May 14, 2024
Project #010014-01-218

RE: Chick-fil-A 1600 Gibson Blvd SE – Traffic Circulation Layout – M15-D012C

Bowman Consulting is in receipt of your comment letters, regarding the above-mentioned Plans Review for Chick-fil-A 1600 Gibson Blvd SE. Please see the following response for further clarification as requested:

C-2.0

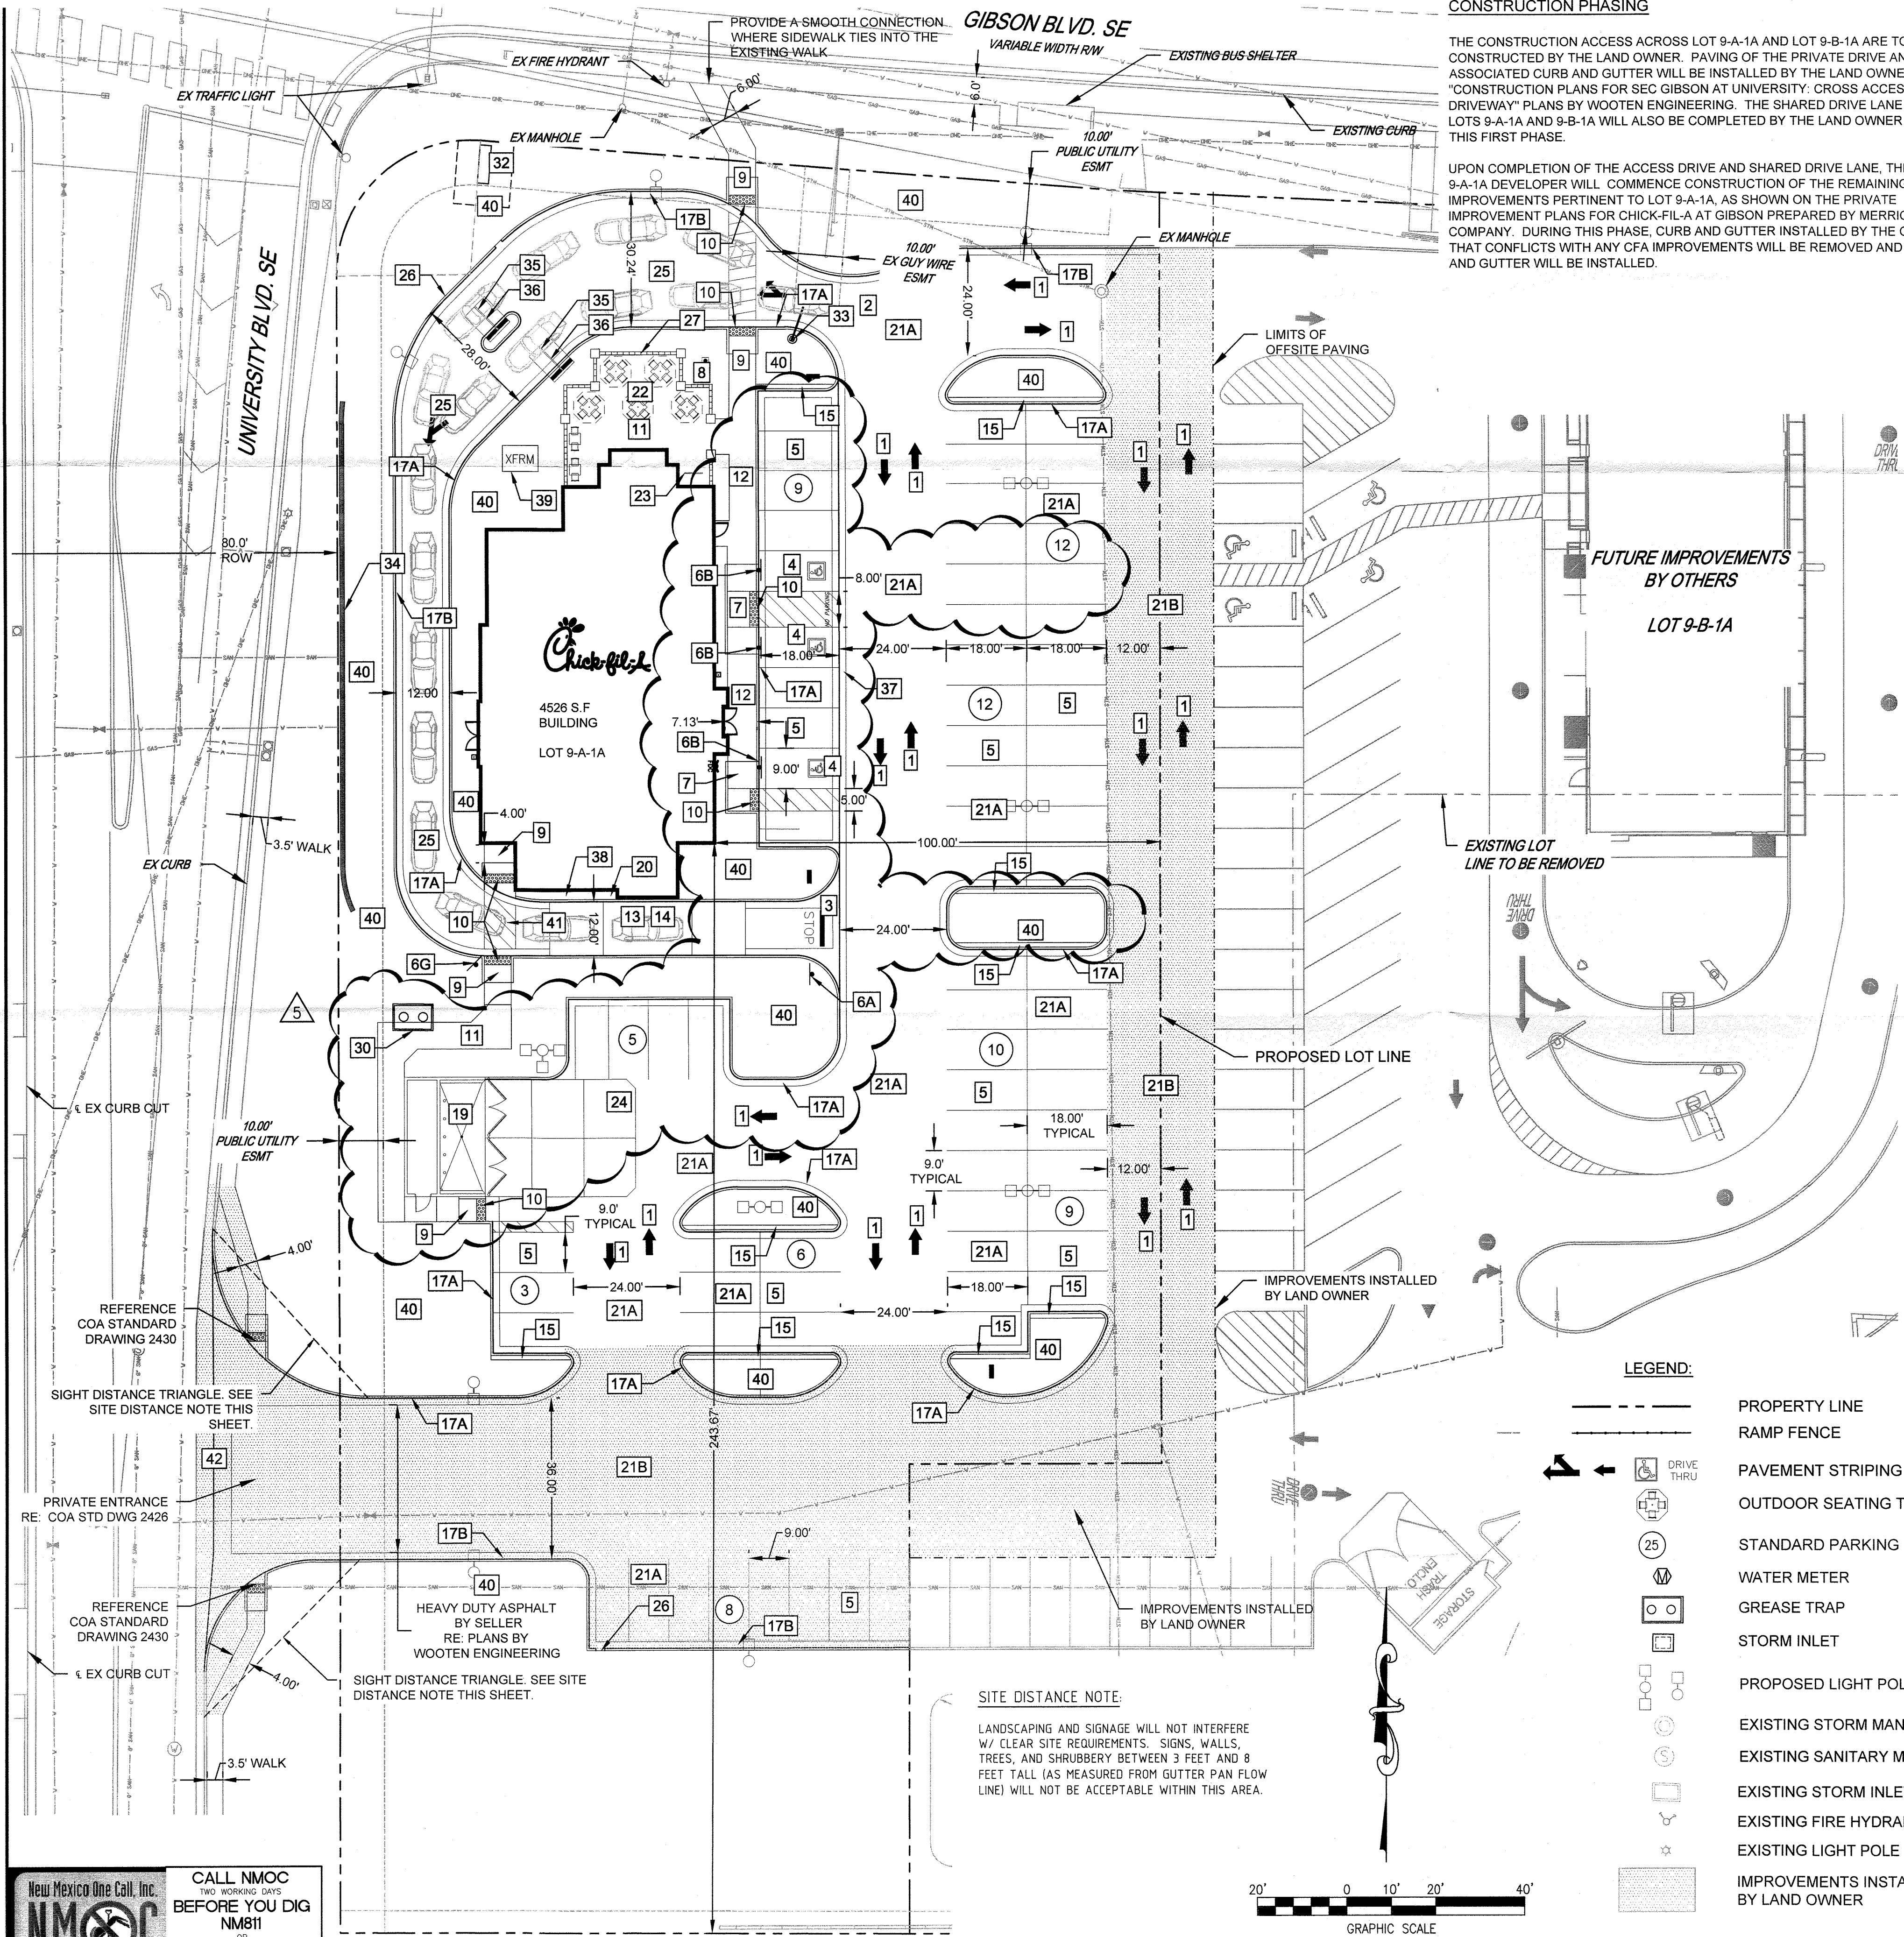
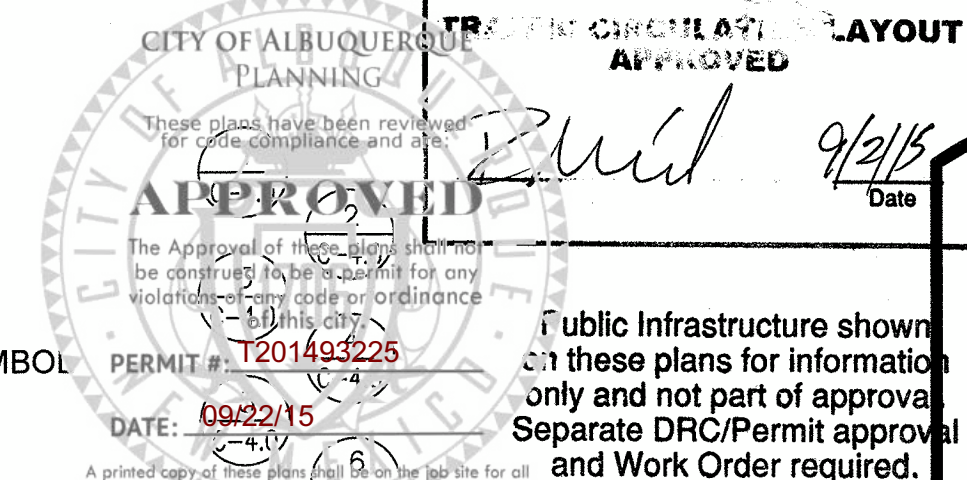
1. Please show a vicinity map on the site plan sheet C-2.0 showing the location of the development in relation to streets and well-known landmarks.

2. The minimum drive through lane width is 12 feet with a 25-foot minimum radius (inside edge) for all turns. (A 15-foot radius can be used with an increase in lane width to 14 feet). Please dimension all lane widths and radii.

3. List the number of Motorcycle and Bicycle parking spaces required by the IDO.

4. Please show on the site plan, the required stacking spaces for the drive-thru lanes.

5. Please provide all the existing ADA ramps details (width, running, and cross slopes). ADA curb ramps must be updated to current standards and have truncated domes installed.

6. The "STOP" & "DO NOT ENTER" signage must be provided at the exit of the drive-thru.

9. A 1-foot clear zone around the bicycle parking stall shall be provided.

10. Bicycle parking spaces shall be at least 6 feet long and 2 feet wide.

11. Please show on the site plan these dimensions.

12. Add a note stating, "All broken or cracked sidewalk must be replaced with sidewalk and curb & gutter." A build note must be provided referring to the appropriate City Standard drawing.

Response: Vicinity map added to sheet C-2.0 – Site Plan.

Response: Drive-through radii have been dimensioned and updated to 25-ft. Please see sheet C-2.0 – Site Plan.

Response: Number of motorcycle and bicycle parking spaces required shown in parking calculations table. Please see sheet C-2.0 – Site Plan.

Response: Required and provided stacking spaces shown in parking calculations table. See sheet C-2.0 – Site Plan.

Response: Existing truncated domes and ramp widths shown on sheet C-2.0 – Site Plan. Running and cross slopes are shown on sheet C-3.0 – Grading Plan.

Response: Signage added at drive-through exit. See sheet C-2.0 – Site Plan.

Response: Bicycle parking area has at minimum 1-ft clear zone. See sheet C-2.0 – Site Plan.

Response: Bicycle parking spaces exceed the minimum dimensions. See sheet C-2.0 – Site Plan.

Response: Dimensions shown around bicycle racks. Please see sheet C-2.0 – Site Plan.

Response: Note added to sheet C-2.0 – Site Plan.
